WA/38/21/HH

1 Orchard Terrace, The Street, Walberton BN18 0PH

Erection of rear extension. This application may affect the character and appearance of the Walberton Village Conservation Area

ARW Design	DRAWING TITLE: EXISTING & PROPOSED ELEVATIONS PROJECT: SINGLE STOREY REAR EXTENSION	LOCATION: 1, ORCHARD TERRACE, THE STREET, WALBERTON CLIENT: S. TWINE	SCALE: AS NOTED @ paper size A3 DATE: APRIL 2021	DRAWING NO: 5091/3
	DRAWN: ARW			REVISION:

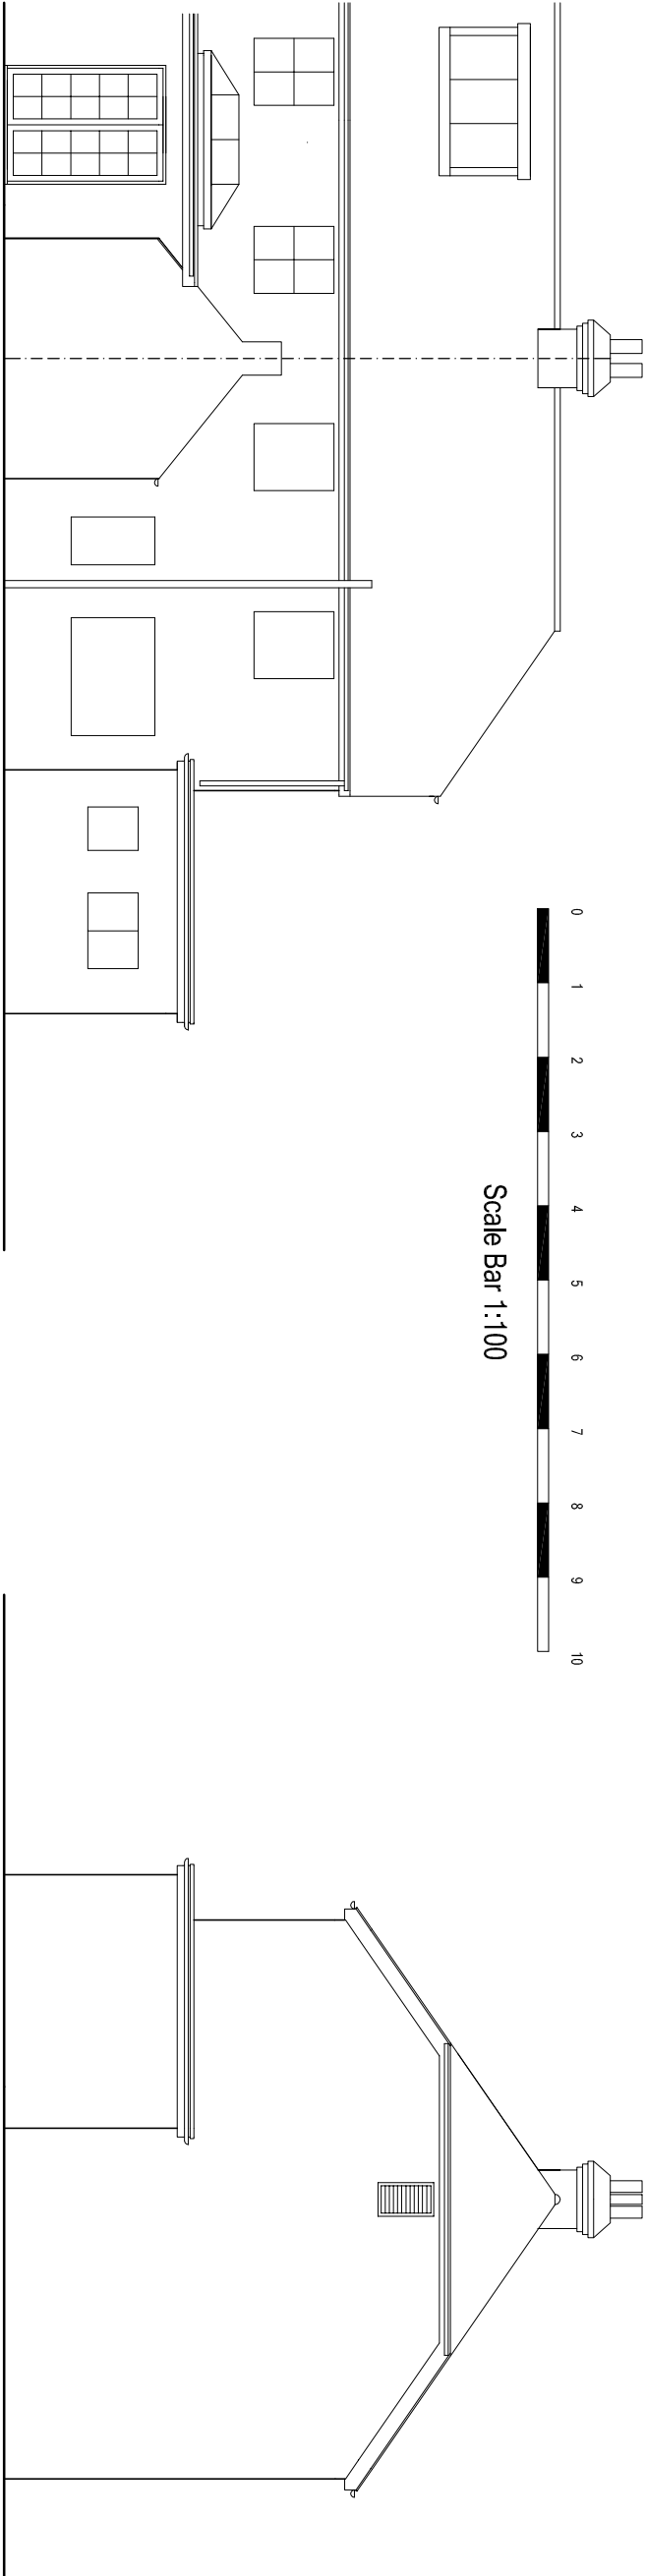
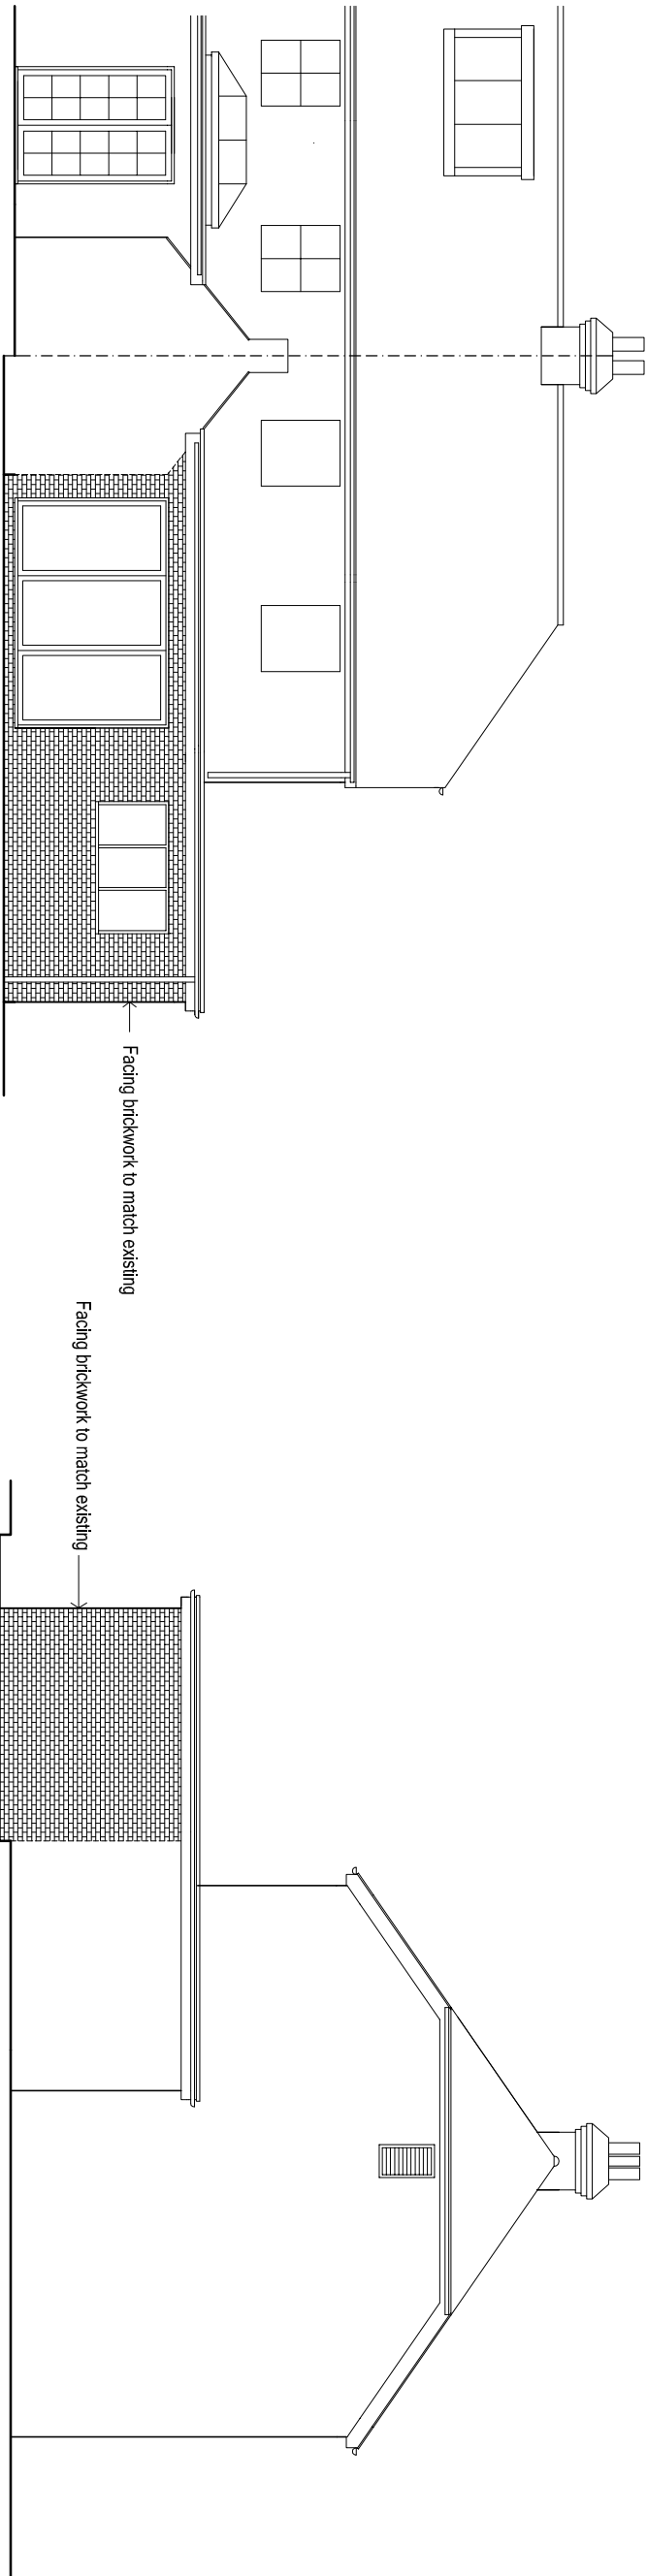
The proposal is for a rear ground floor extension, which will incorporate an existing space currently used as a utility room. It would appear from the proposed elevations that this approach has already been used by the immediate neighbour.

The design of the proposed extension is simple in appearance and would not detract from the rear elevation of the building. The facing brickwork will match those on the existing rear elevation, which is also positive. Further, the location of the extension is such that it cannot be seen from The Street and as a result, it will not harm the conservation area.
